# Technical Note 1: Highways

Project: Dobroyd Mill, Jackson Bridge / Hepworth,  
West Yorkshire

31 July 2017

This Technical Note has been written in response to comments made by Kirklees Metropolitan Council's (KMC) Highways Officers on planning application reference 2017 / 90620. The document was not dated nor is it annotated except by headings and the pages (6 no.) are not marked. Reference is therefore made to the pages (1 to 6 in the Word document) and headings as appropriate. The said document is attached to this Technical Note.

DRAWING No: 1604602a

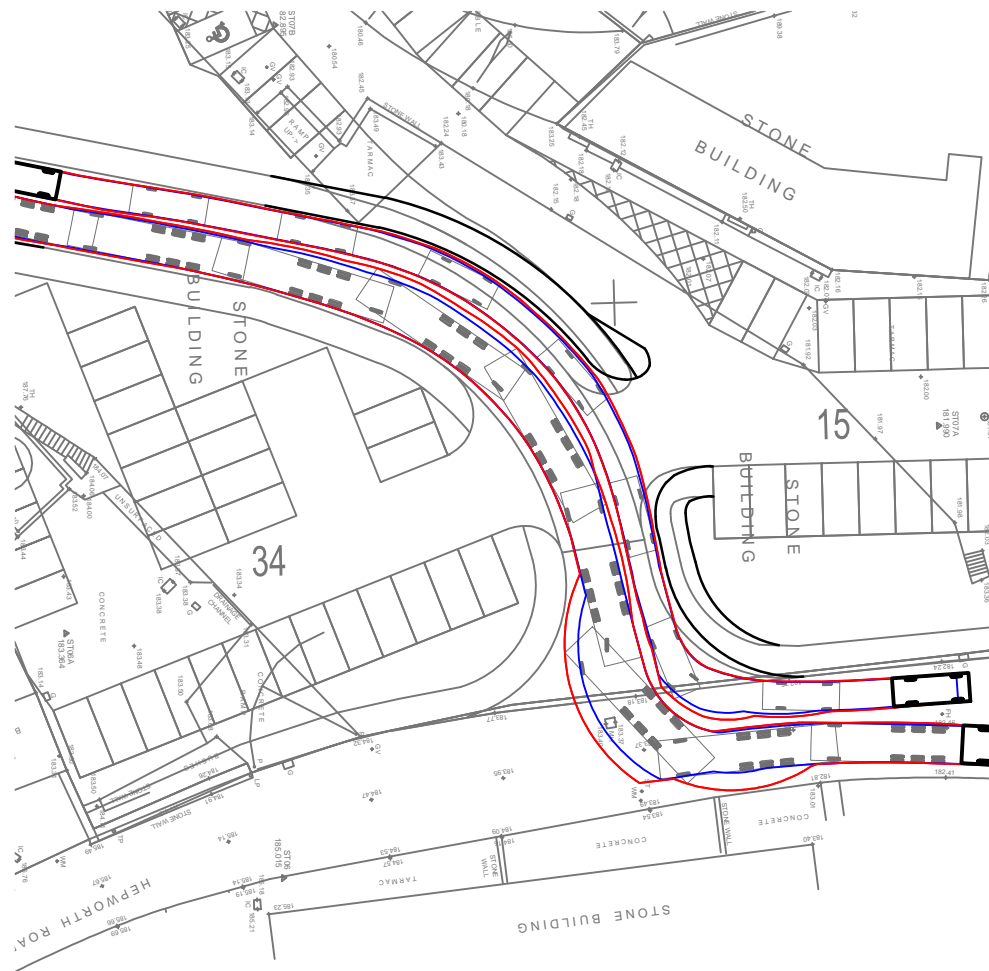
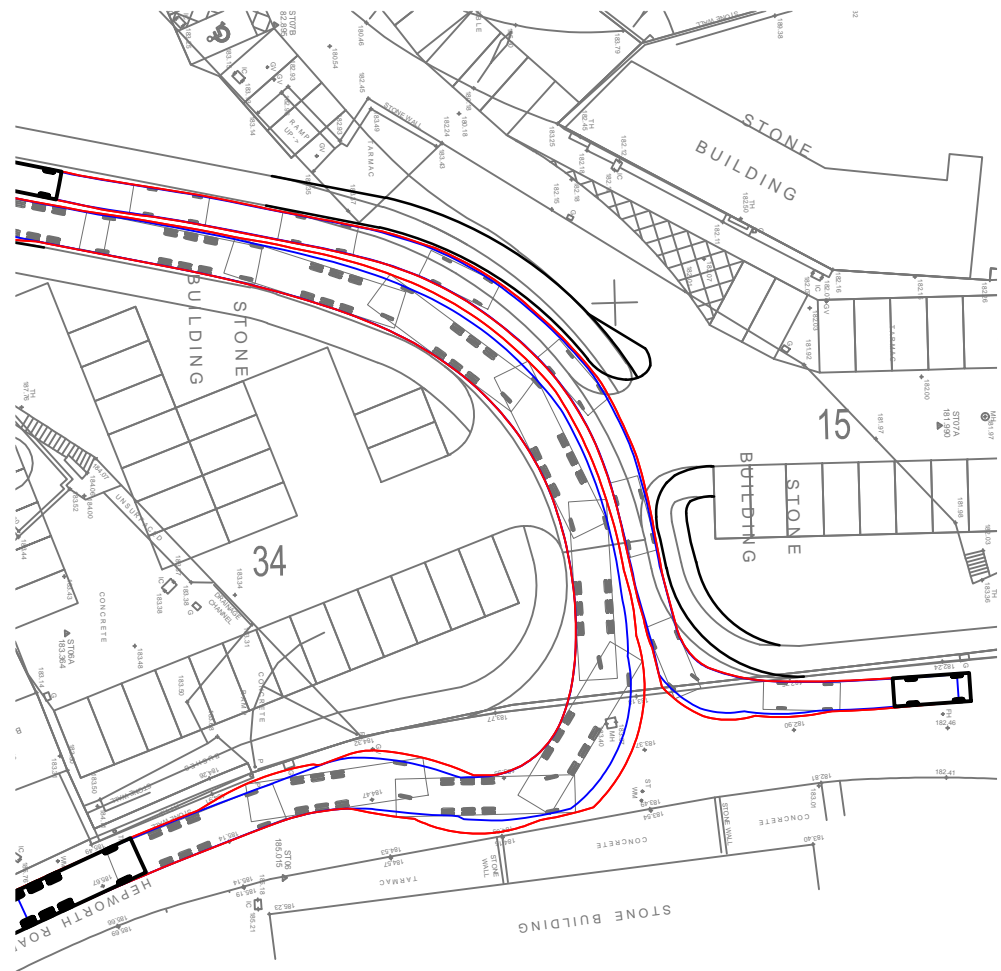
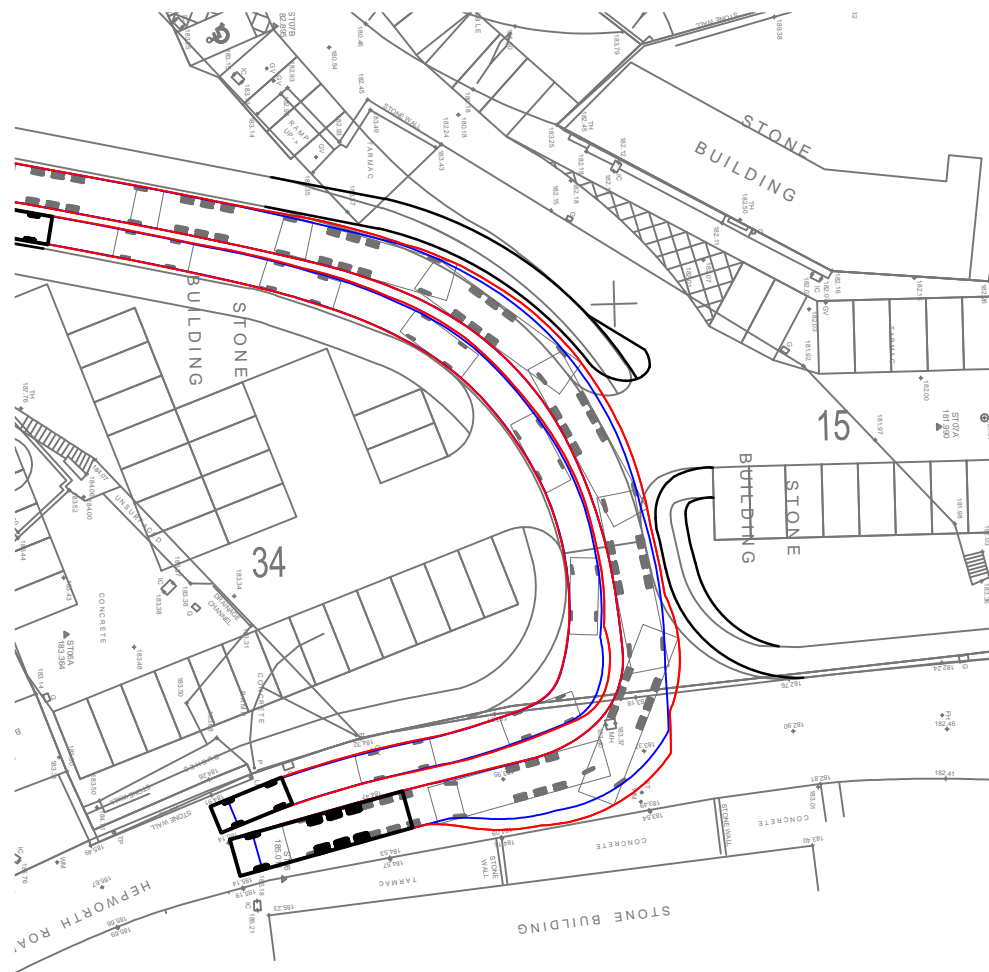
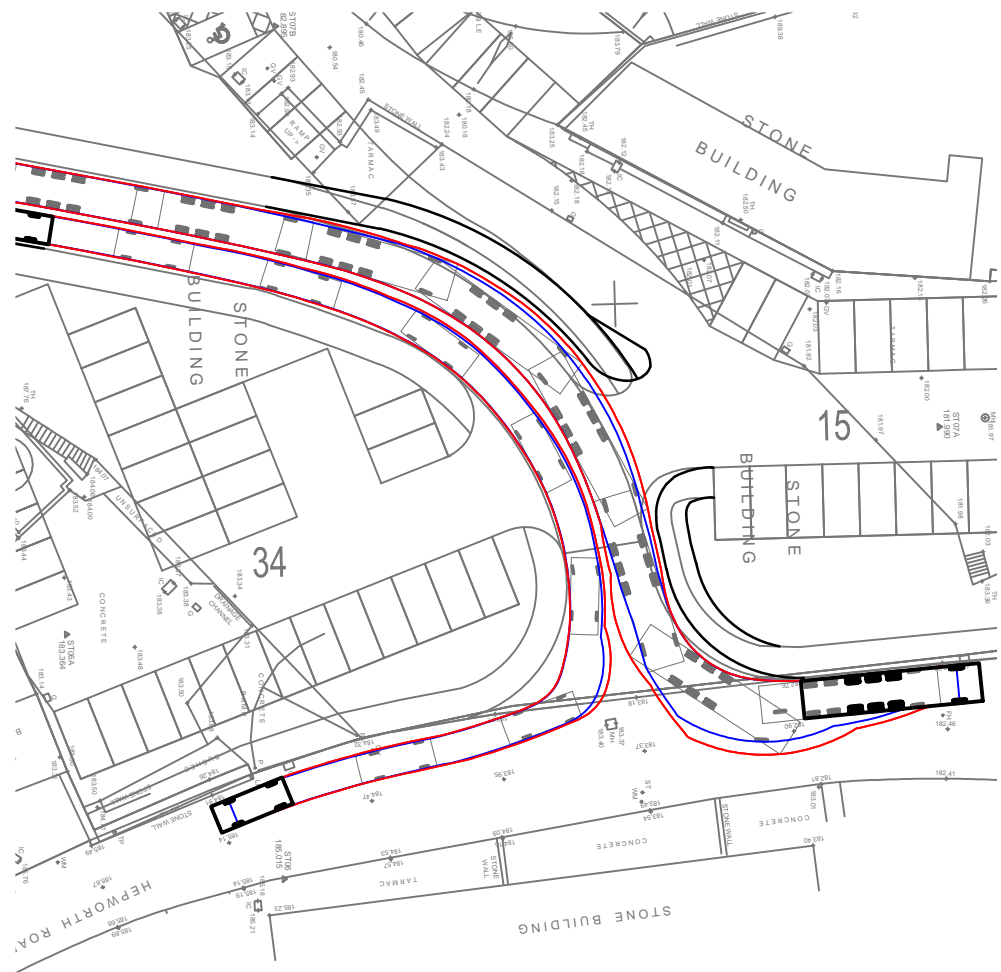
This same response can be applied to the comment regarding swept path analyses of the internal road layout – this is an Outline application for this element of highway works. A swept path analysis of the junction with Hepworth Road has been prepared and is attached to this Technical Note.
